**Consultation Response from KC,
Building Control**

2023/93495 Land rear of, Yorkshire House, South Street, Dewsbury, WF13 1JT

Erection of hotel (within a Conservation Area)

Responding Ref: 2024/00907

Drawing Number:  
**21-055-52**

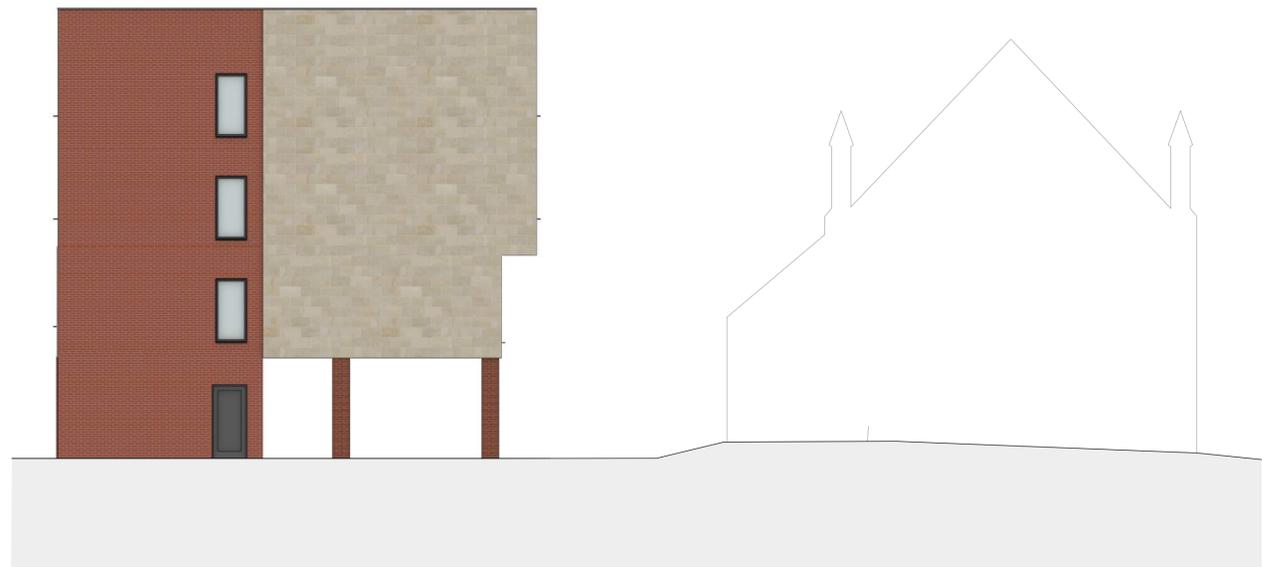
- 1) Full Plans Building Regulations Application will be required for the works to a Building Control provider.
- 2) It is noted to the rear of 67&69 Daisy Hill there is a dilapidated building adjacent the proposed site boundary and close to the proposed Hotel building/elevation. We would recommend every effort and or opportunity provided to the building owner to ensure the external envelope of the building is maintained. Once the Hotel is erected any refurbishment/demolition works on this property externally, would be problematic.

Ground Floor Site Plan As Proposed  
Scale 1:100  
0m 1m 2m 3m 4m 5m

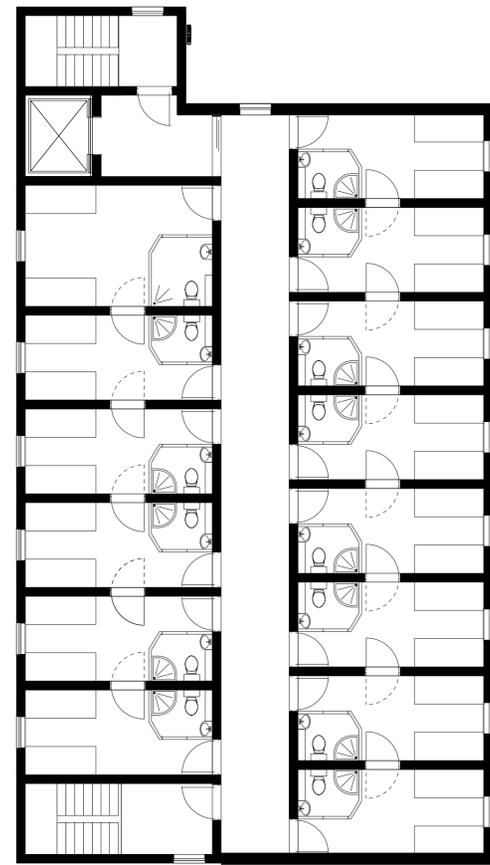
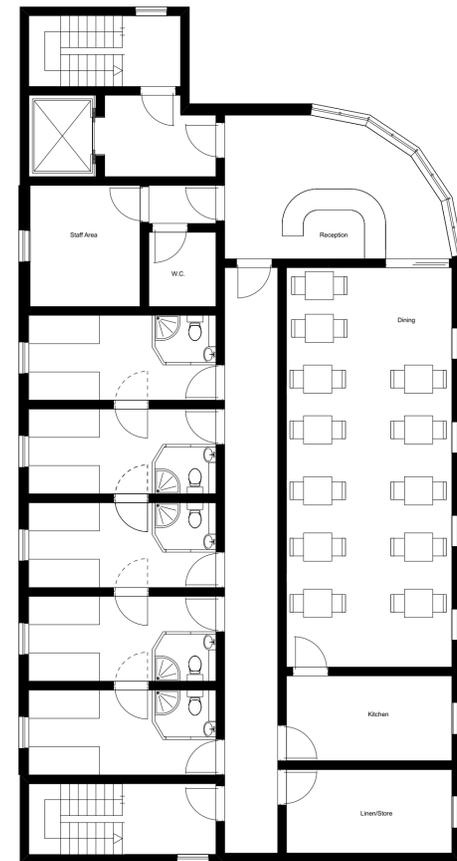
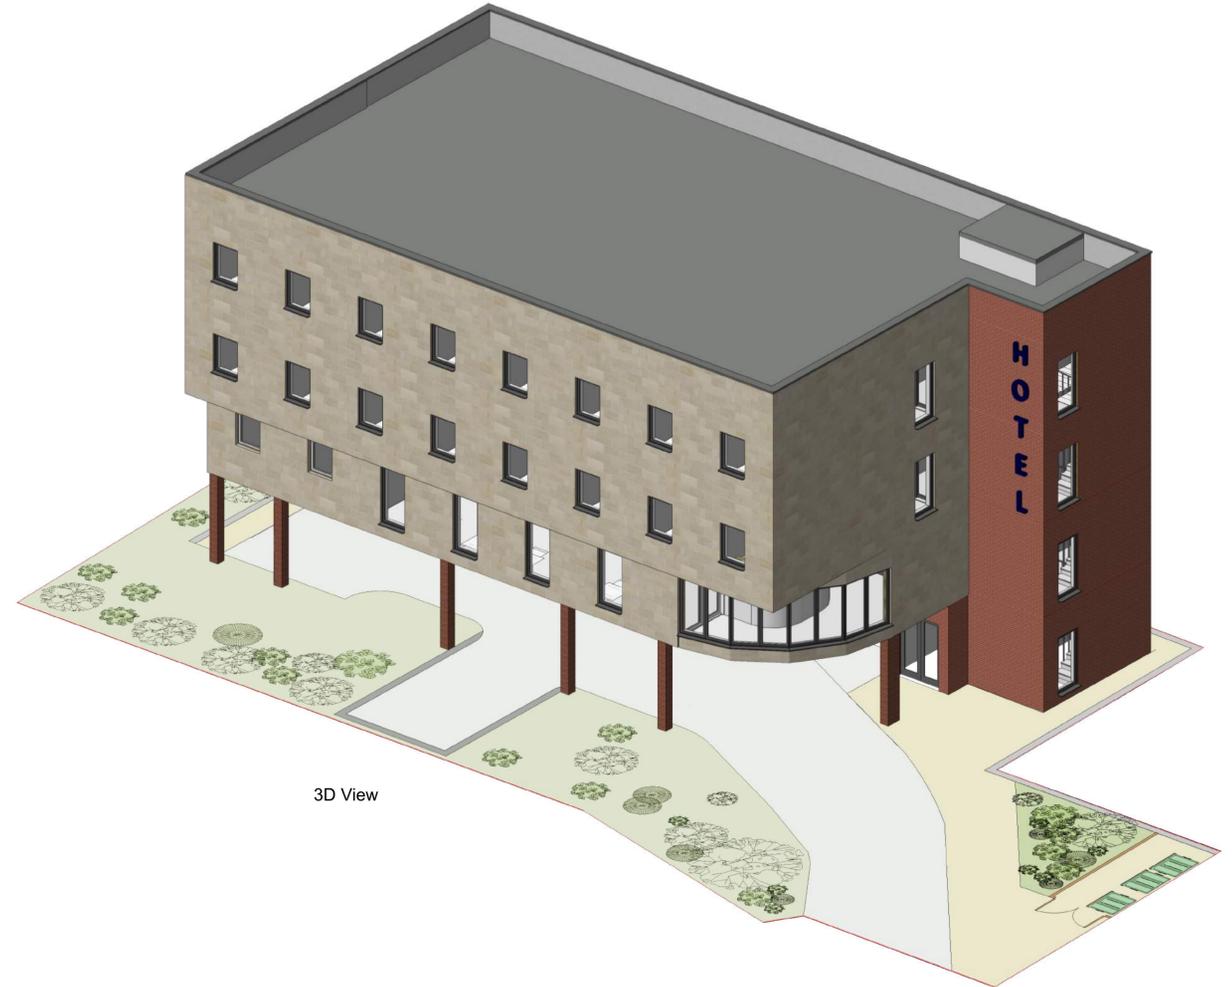
- 4) The floor plans don't suggest a standard hotel layout- where 2No. single beds are provided against a wall to each room with inter-connecting doors to all rooms.
